A303 Sparkford to Ilchester Dualling Scheme TR010036

8.3 Statement of Common Ground with Historic England

DRAFT STATEMENT OF COMMON GROUND

This Statement of Common Ground has been prepared and agreed by (1) Highways England Company Limited and (2) The Historic Buildings and Monuments Commission for England (HBMCE).

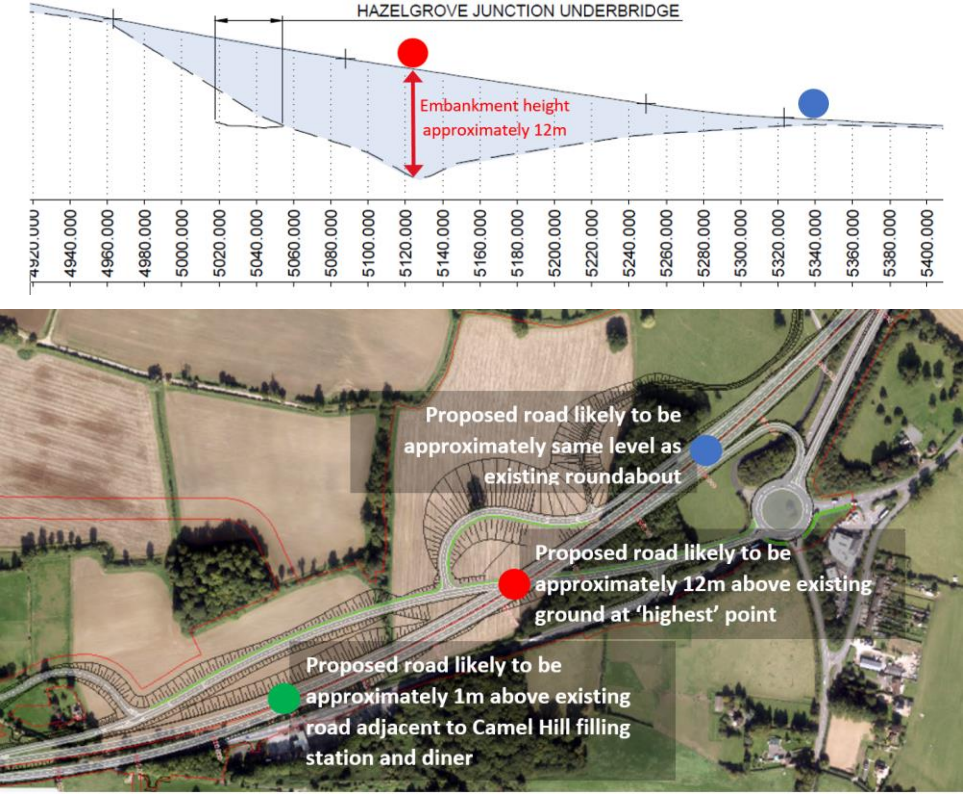
<p>CS provided an overview of the anticipated heights of the new junction layout at Hazlegrove RPG, using the below images to aid the discussion.</p> <p>SM asked to see cross sections to show the slope profiles from the Hazlegrove House key view. CS confirmed that the design team could develop these and issue for information shortly.</p>	CS / OM to develop
